Our ref  
PLAN-038754

Date  
30/04/2021

**Proposal:** Approval of details reserved by condition imposed under ref LU/287/17/PL relating to Condition Nos 7 - divert public sewers and 8 - foul & surface water sewerage disposal.

**Site:** LU/111/21/DOC: - 46a & 47 Pier Road and Land North of Clifton Road, Littlehampton, BN17 5LW.

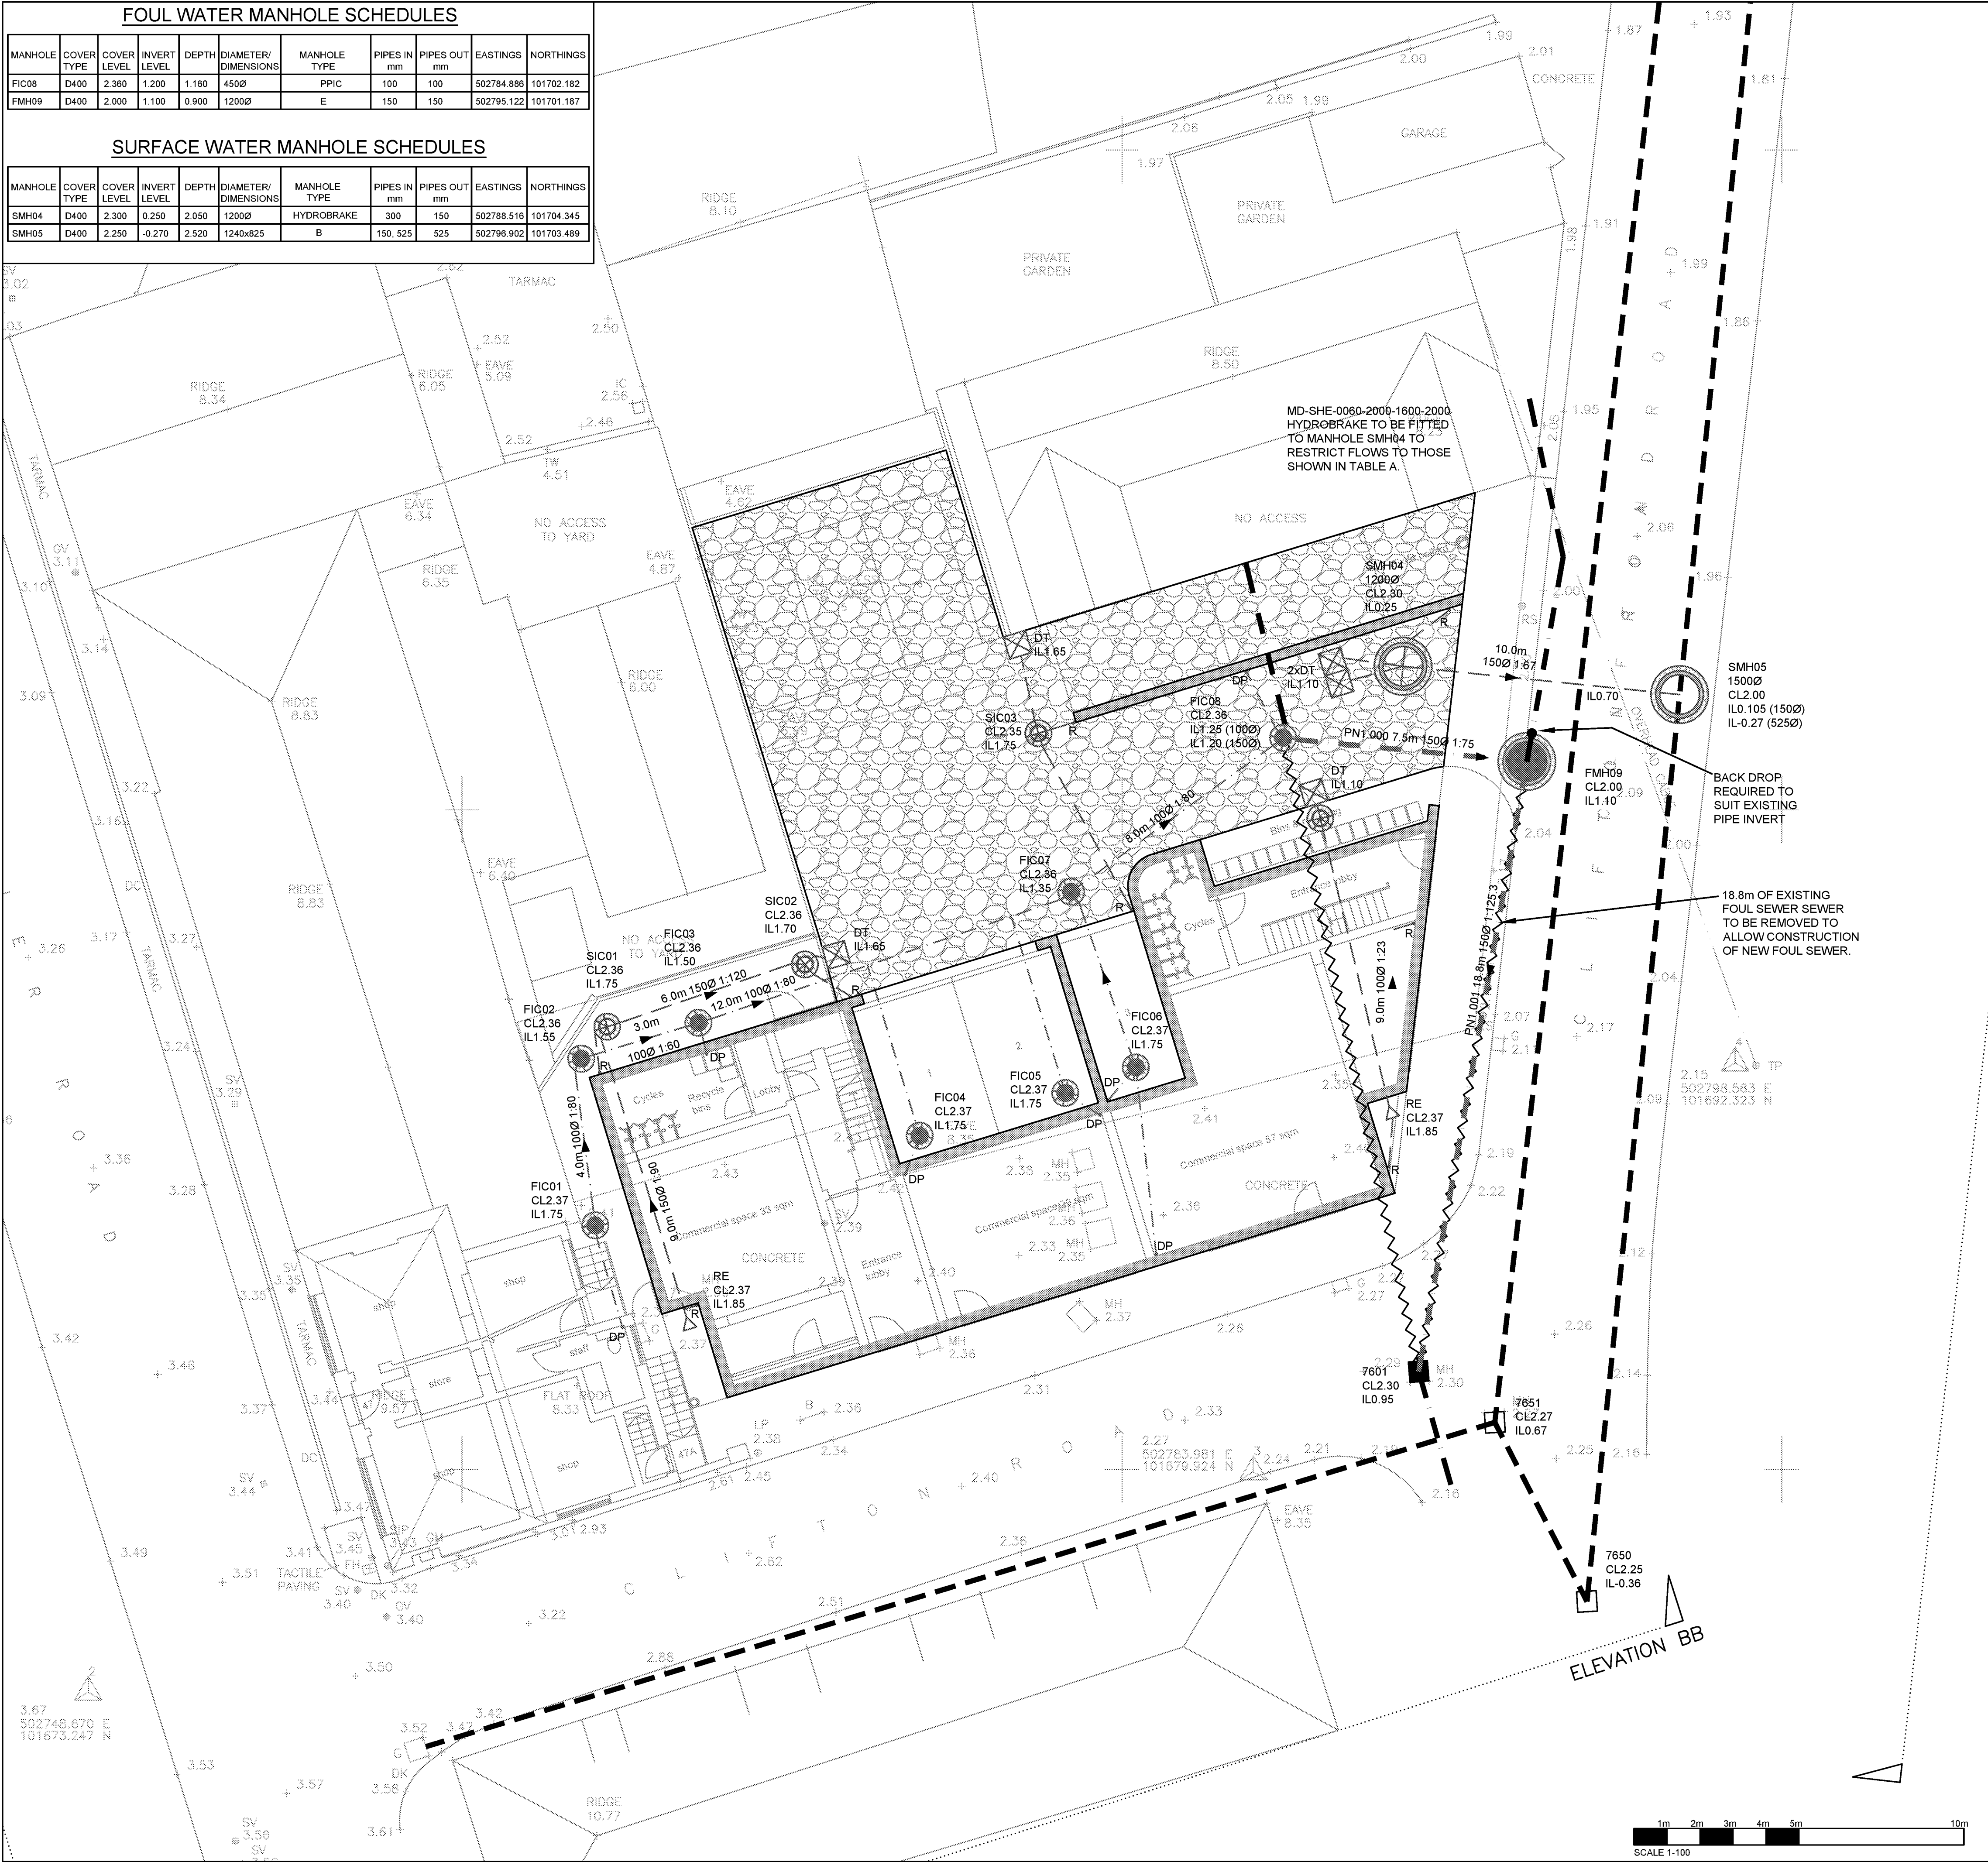
Southern Water cannot recommend discharge of condition 08 relating to surface water drainage. Drainage from the attenuation tank is communicating to the Southern Water public sewerage systems. Please note Attenuation tank should be sealed with impermeable membrane to avoid ingress of ground water. The design of drainage should ensure that no land drainage or groundwater is to enter public sewers network.
